Appeal Decision

Appeal Ref: APP/R5510/W/18/3200914

42 Hughes Road, Hayes, UB3 3AW

- The appeal is made under section 78 of the Town and Country Planning Act 1990 against a refusal to grant planning permission.
 - The appeal is made by Mr Kuldip Kaur Lachhar against the decision of the Council of the London Borough of Hillingdon.
 - The application Ref: 28763/APP/2017/4032 dated 7 November 2017, was refused by notice dated 8 February 2018.
 - The development proposed is a part two-storey, part single storey side/rear extension and conversion of roof space to habitable use to include a rear dormer and 2 front roof light to create 1 x 2-bed flat, 1 x studio flat and a 4-bed HMO.
-

42 HUGHES ROAD, HAYES. UB3 3AW.
PROPOSED INFORMATION

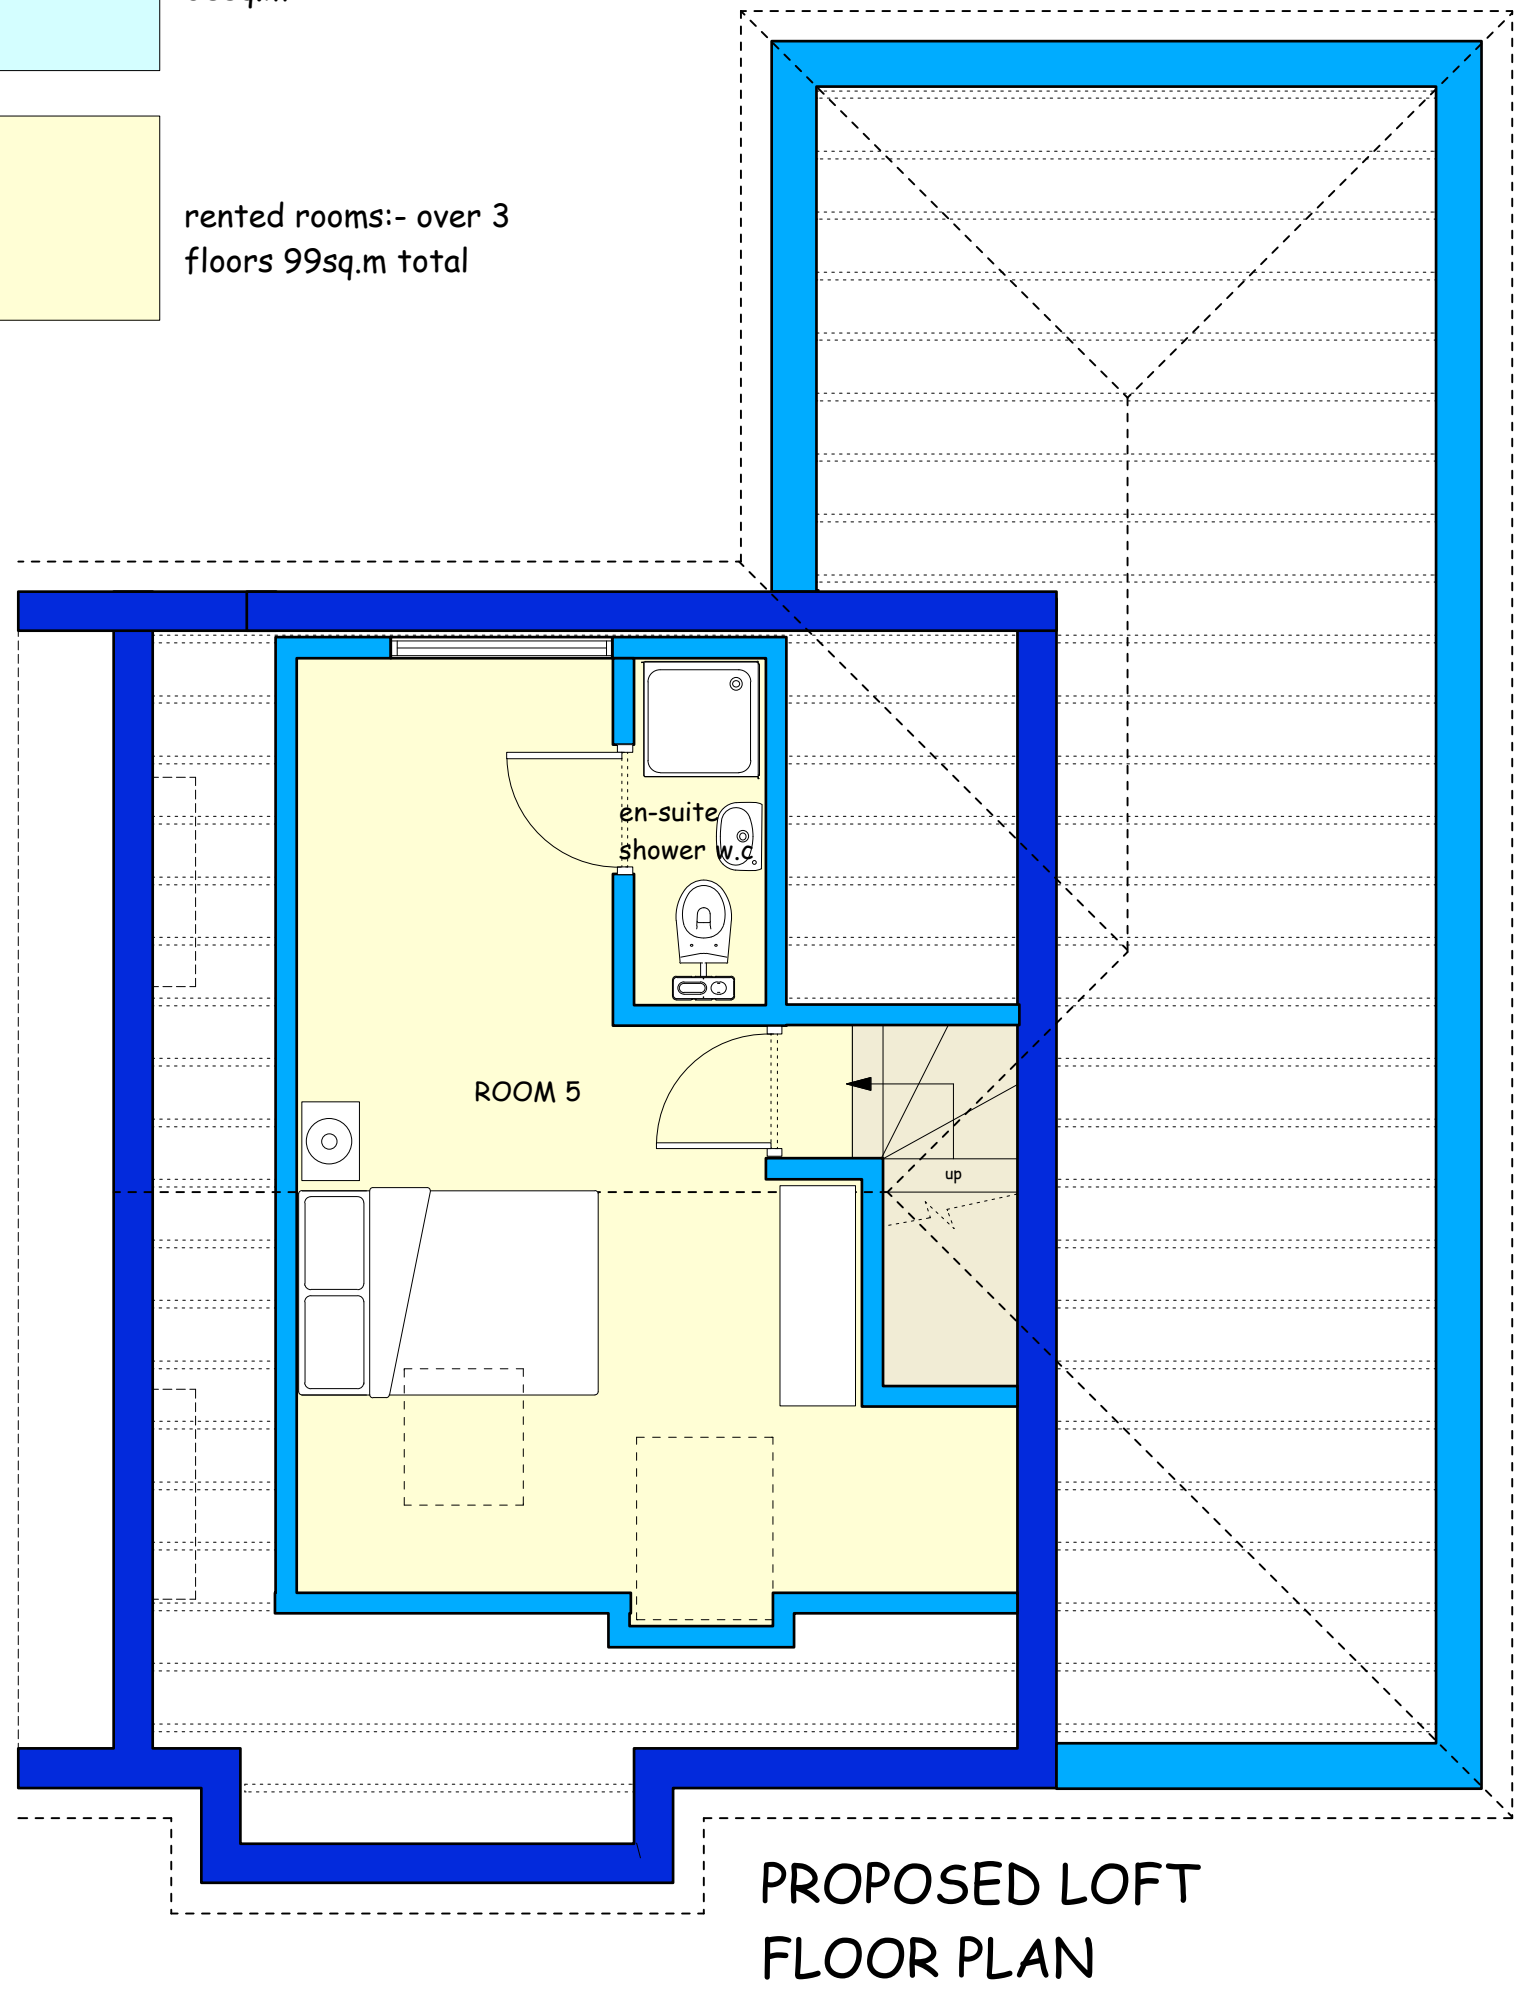
5. Of the single-occupation flats, a studio flat (flat B) on the ground floor would have an internal floor area of 38 square metres, and a two-bedroom flat arranged over the ground and first floors would have an internal floor area of 62 square metres. The Government's adopted *Technical Housing Standards – Nationally Described Space Standard* (2015) (NDSS) set out minimum floor space provision in new residential development, which is applied within London through Policy 3.5 of *The London Plan* (2016). The NDSS requires a two-bedroom, three-person flat set over two floors to attain a minimum floor area of 70 square metres, which the proposed development would not achieve. Given that the standard is a basic indicator of good design and appropriate living conditions, the proposed development is not acceptable for this reason.

6. The Council has adopted its own standards in respect of the provision of floorspace in HMOs (SPG).² This recommends that rooms should have a minimum floor area of at least 6.5 square metres. One of the proposed HMO rooms would not achieve this and be undersized by around 1.5 square metres, which is a significant under provision for an already small room. The SPG also recommends the provision of a habitable room of at least 10 square metres, to be used as a common leisure space by occupiers, and this would not be provided. I acknowledge the appellant's comments that outdoor amenity space would be shared, but this would not allow for the provision of an all-weather leisure space of the form intended by the Council, to the detriment of future occupiers.

PROPOSED GROUND AND SITE PLAN
scale:- 1:100@A1

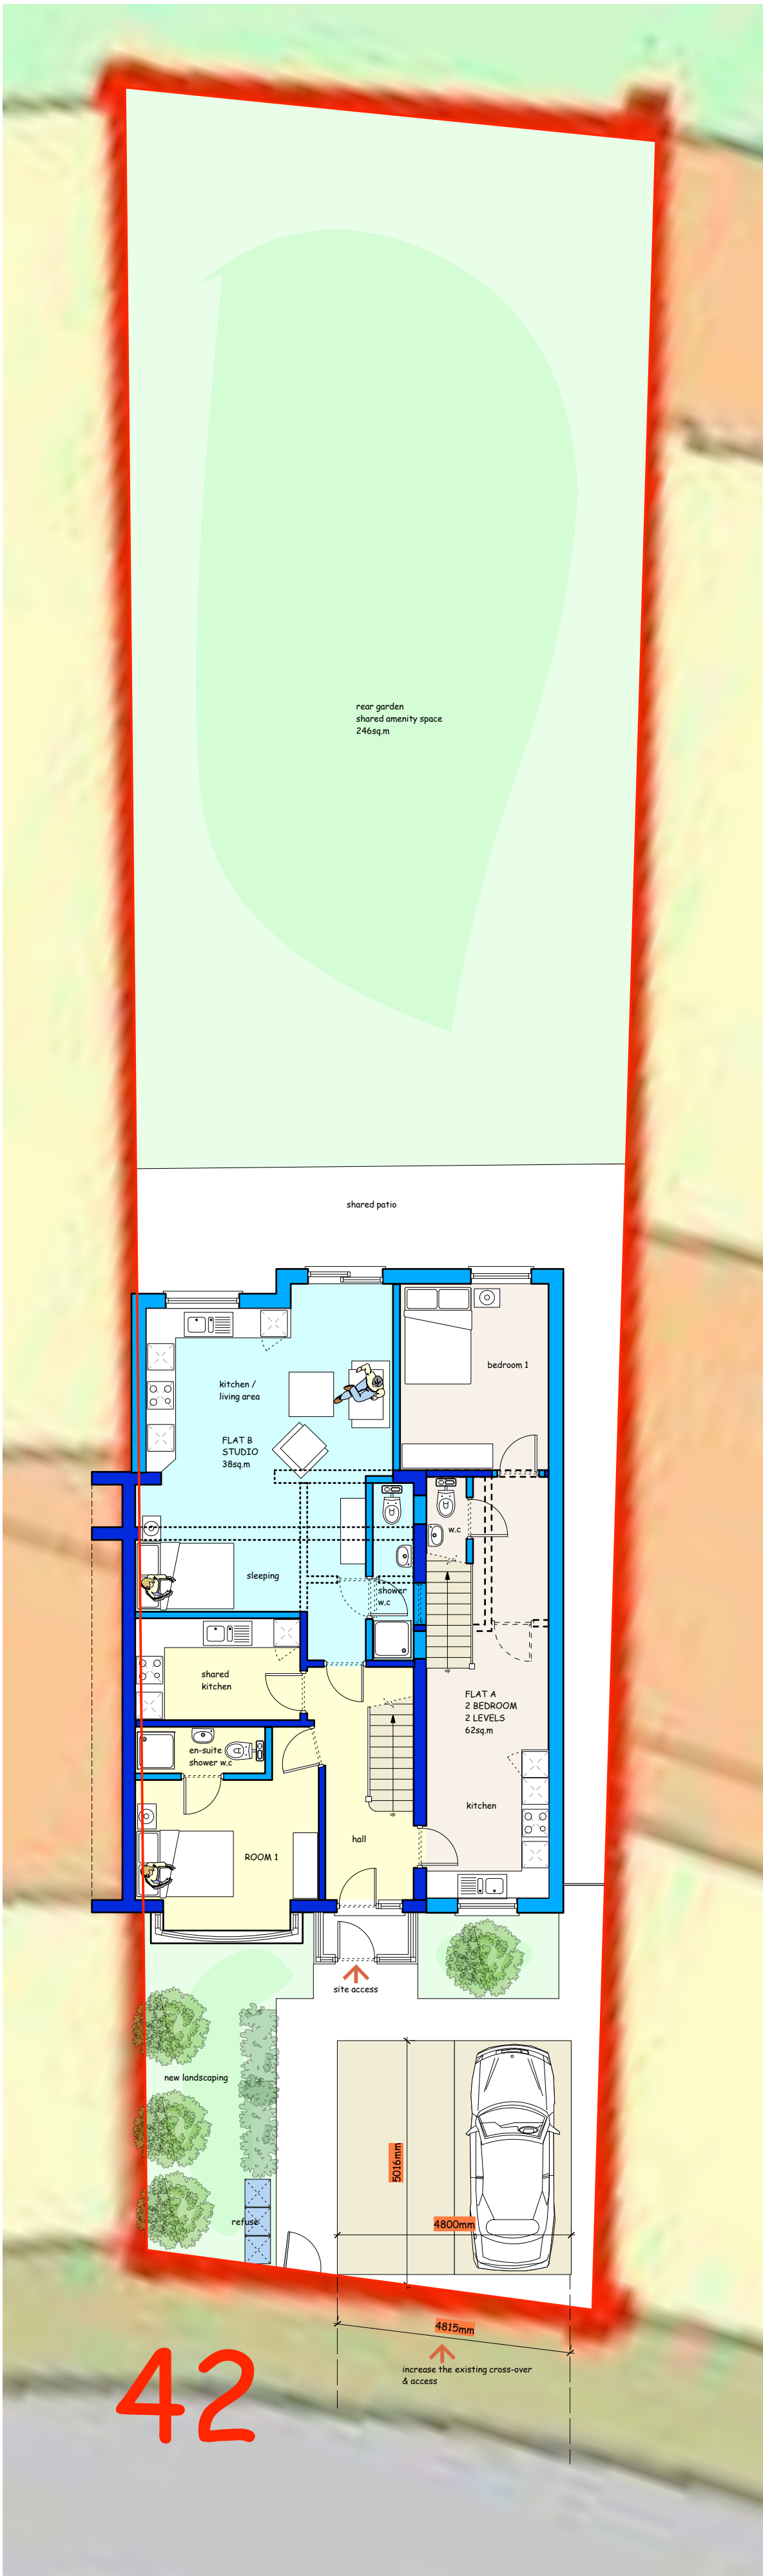
7. The appeal plans indicate that the existing rear garden would be space shared between the occupiers of all of the proposed flats, and this includes a patio area immediately adjoining the rear of the building. Windows and doors serving habitable rooms for two of the flats would face directly onto the patio, and there would be potential for overlooking of the occupiers of these rooms from any users of the patio. This would result in limited privacy for the occupiers of these flats, together with potential disturbance arising from any activity taking place on the patio close to private living areas, with resultant poor living conditions.

12. The Council's approach to parking provision is set out in UDP Policy AM14 and the accompanying Annex 1. These suggest that the maximum on-site parking requirement for the proposed development would be five bays. Two on-site parking bays would be provided.

13. The site's poor public transport accessibility level of the site means that occupiers of the proposed development are likely to use private vehicles in preference to more sustainable modes of transport. Additionally, no cycle parking is shown on the appeal plans. Given the high parking space requirement and shortfall of provision within the proposed development, it is likely that the proposal would generate demand for on-street parking. I observed that the on-street parking areas in the vicinity were limited, and that there were no vacant bays close to the site at the time that I visited, suggesting that on-street parking is already subject to significant demand. Further pressure on demand would disadvantage existing residents. Moreover, a shortage of on-street parking spaces in areas of high demand can lead to additional traffic congestion as drivers search for available bays, which in turn would be potentially harmful to highway safety.
